**RE: Access Logistics Park, 884-928 Mamre Road, Kemps Creek – SSD 17647189
Response to Submissions**

We refer to the relevant submissions received in relation to the State Significant Development known as the Access Logistics Park (SSD-17647189¹). Specifically, reference is made to the submission by Transport for NSW (TfNSW, dated 18 November 2021) which raise comments with regard to the submitted design and transport assessments.

TABLE 1: TfNSW SUBMISSION RESPONSE

**TEMPORARY ENTRY PLAN - SHEET 1**  
SCALE 1:500

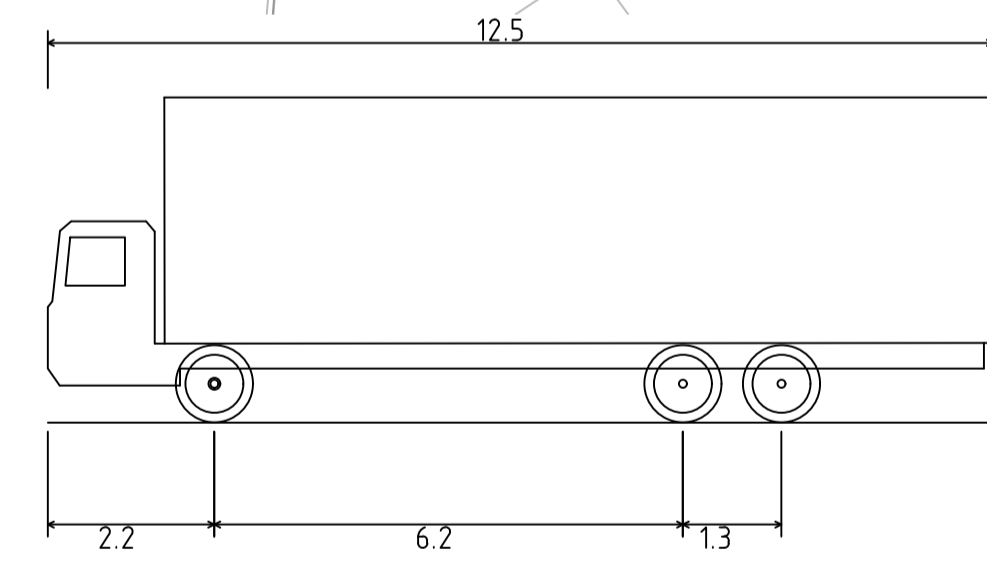
Construction Traffic Management Plan (CTMP)	
3.7	<u>Comment</u> Section 2.3.2. - has swept paths been undertaken for figure 6 to demonstrate that anticipated largest truck can turnaround at the proposed locations?	Swept paths have NOT been undertaken as part of the preliminary CTMP. However, it is noted that the approved CTMP for construction of the Kemps Creek Warehouse, Logistics, and Industrial Facilities Hub (SSD 9522) adopted similar routes. Given that construction of that estate is already underway, and we are unaware of any implementation issues, we trust retention of this construction access route is also suitable for the purposes of this Application.
	Green Travel Plan
